Geotechnical and Construction Materials Testing Services

October 26, 2025

Re: Footing Projection
391 & 397 Cypress Church Road
Harnett County, North Carolina
GeoTechnologies Project No. 1-25-0952-EA

FOUNDATION PLAN

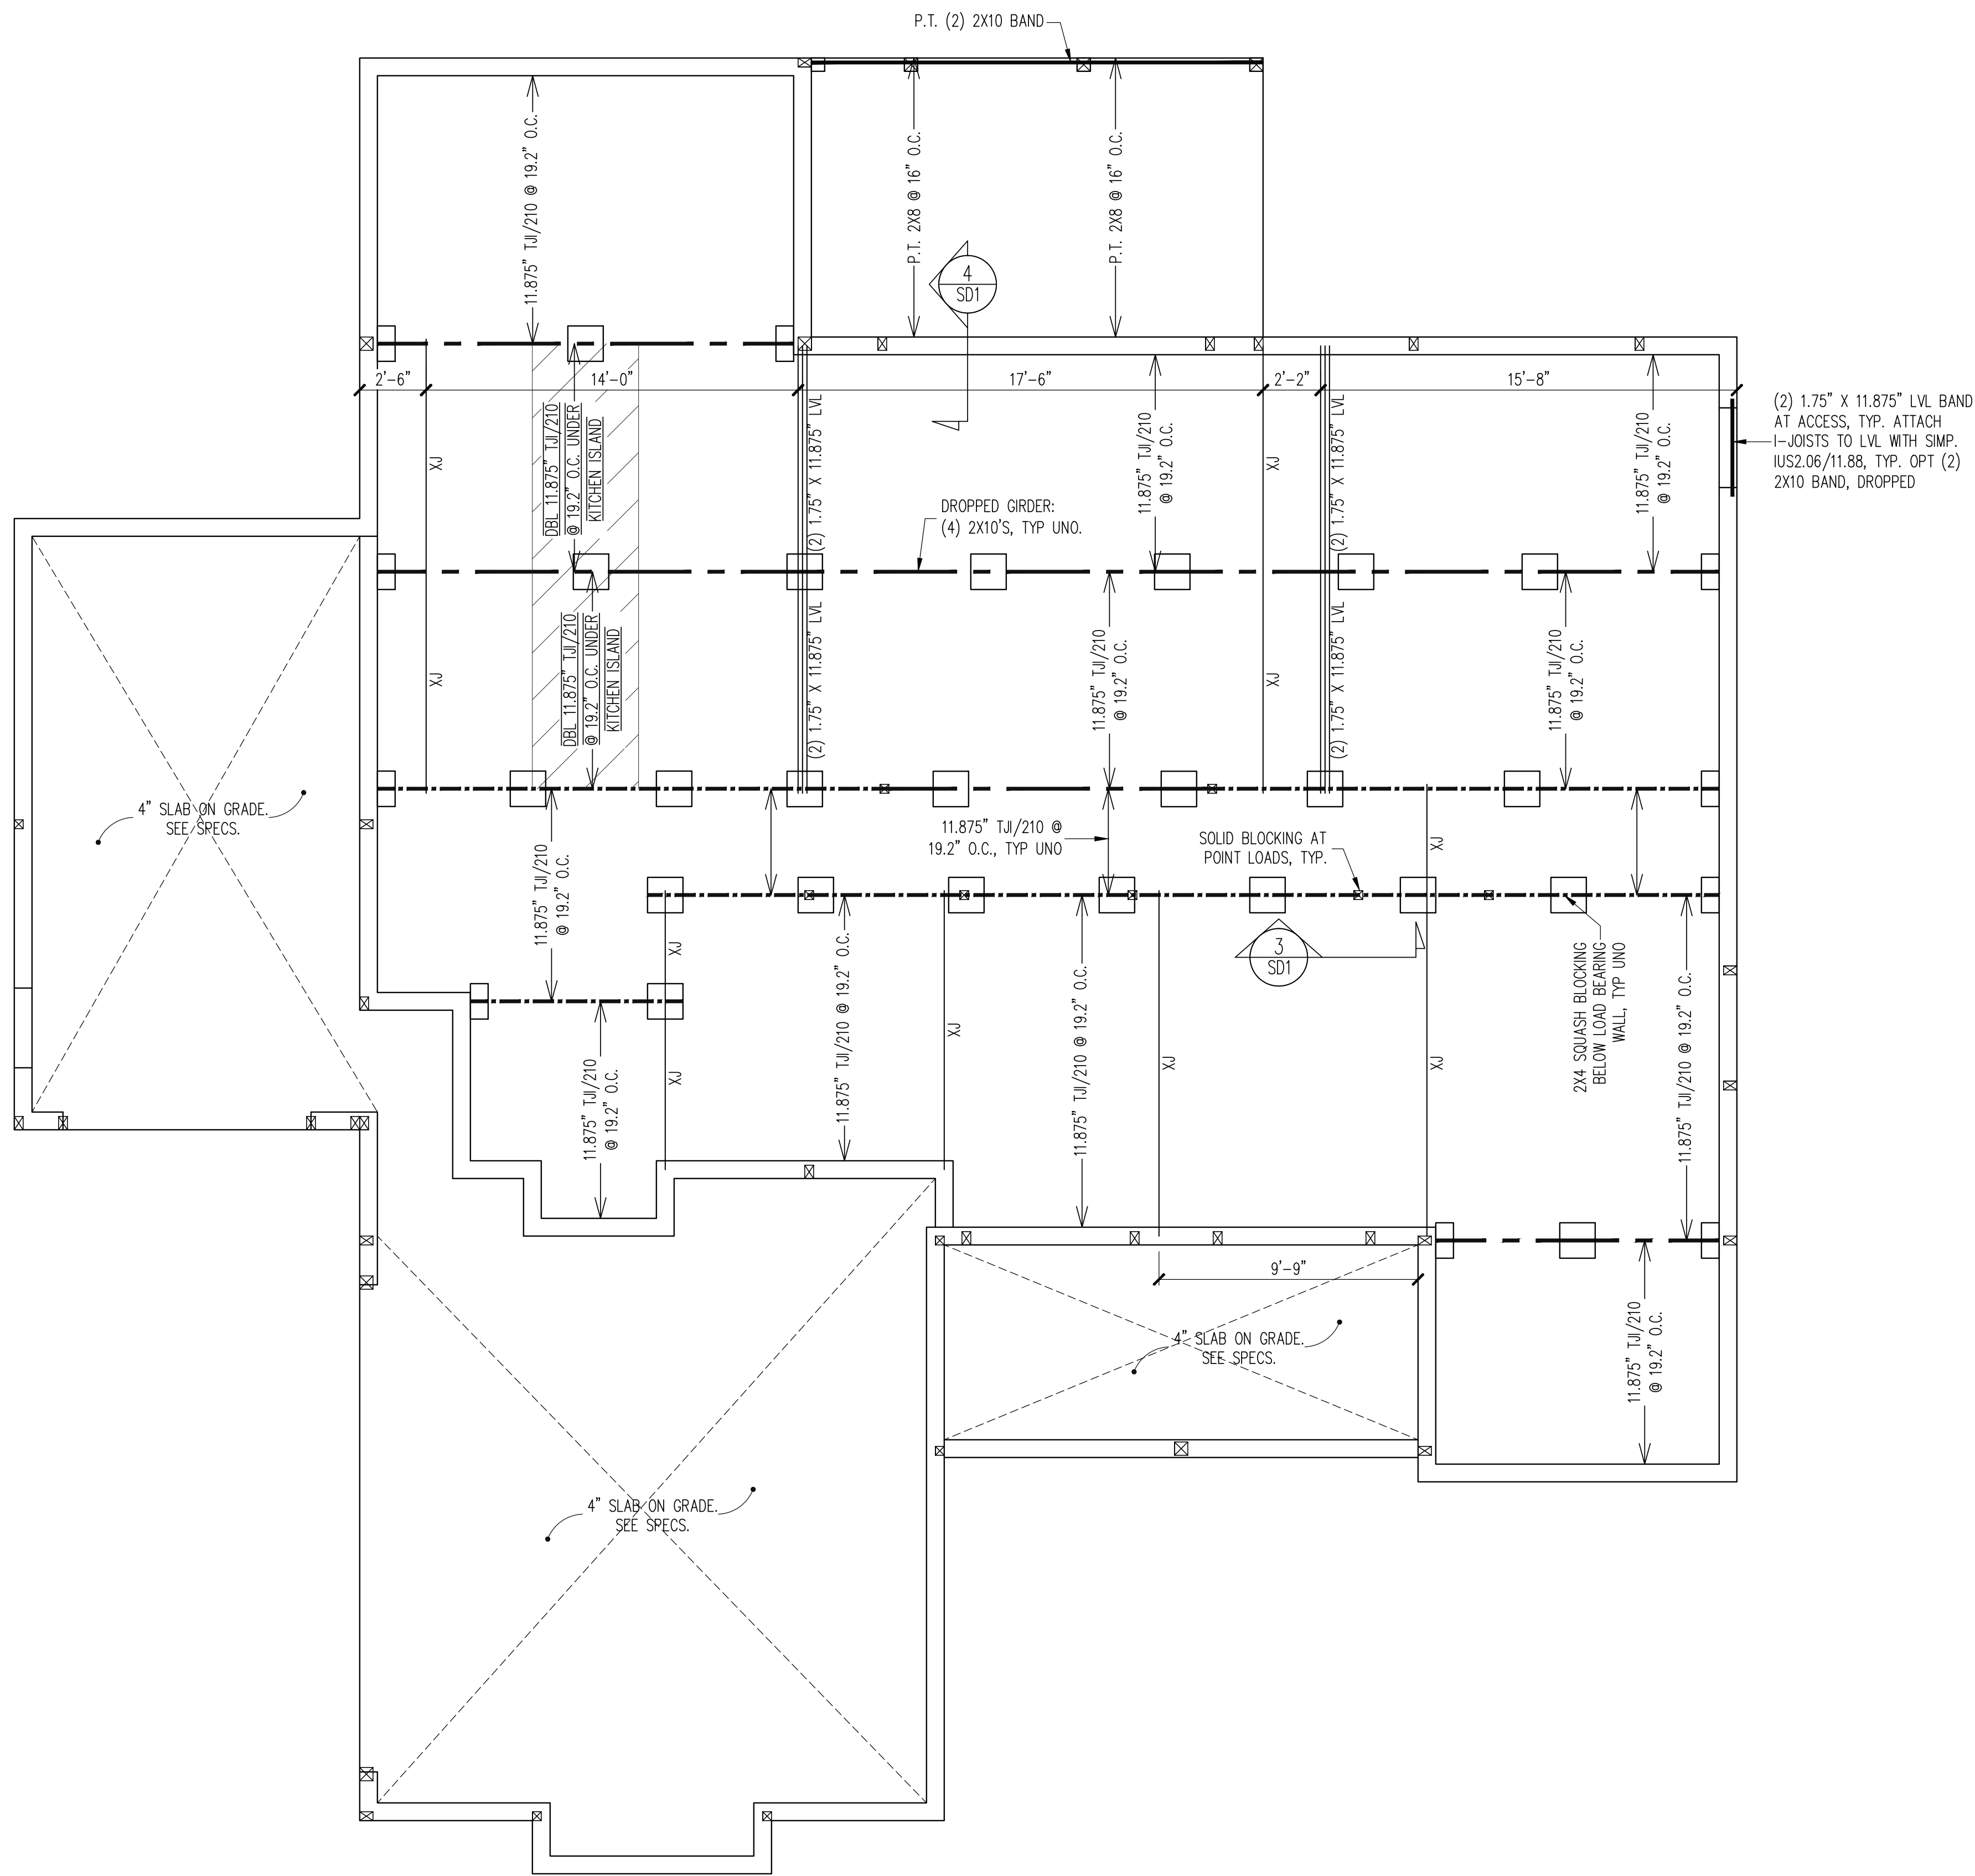
As requested, a representative of GeoTechnologies, Inc. visited the referenced under construction residences to evaluate footing projection. Projection was evaluated with a ½" probe rod. Areas found to be under projected (2 spots at 391 Cypress Church Road and 1 spot at 397 Cypress Church Road, see attached plans) were repaired by excavating to firm soils and then doweling #4 rebars into the existing concrete. The footings were then extended by placing new concrete. Based on our evaluation, the footings at both residences have adequate projection.
